Project Special Provisions
(Version 06.5)
Signals and Intelligent Transportation Systems

1. 2006 STANDARD SPECIFICATIONS FOR ROADS & STRUCTURES

The 2006 Standard Specifications are revised as follows:

SHEET 2 OF 3  
**1725D01**

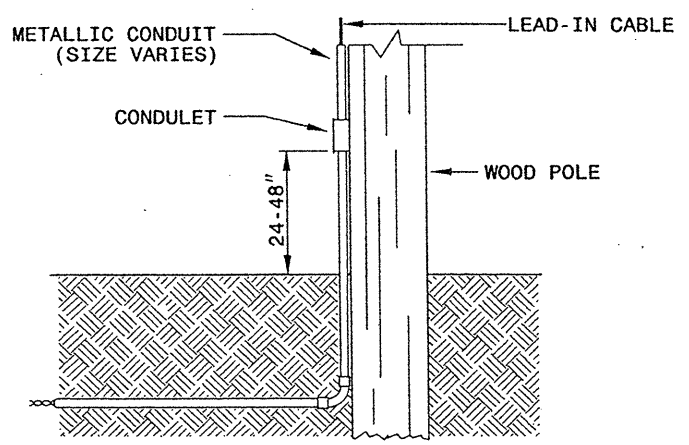
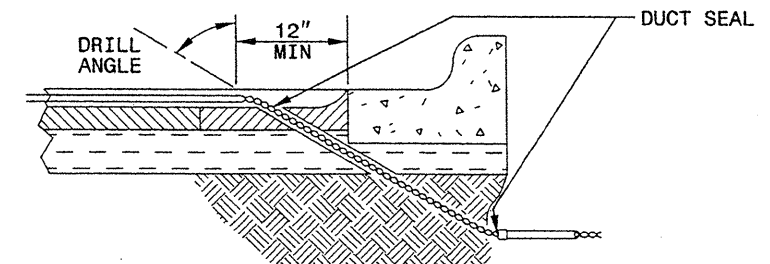
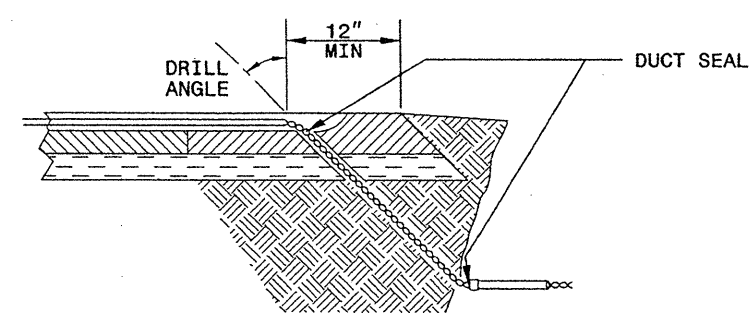
“Twist loop conductor pairs a minimum of 5 turns per foot from where conductors leave saw slot to junction box.
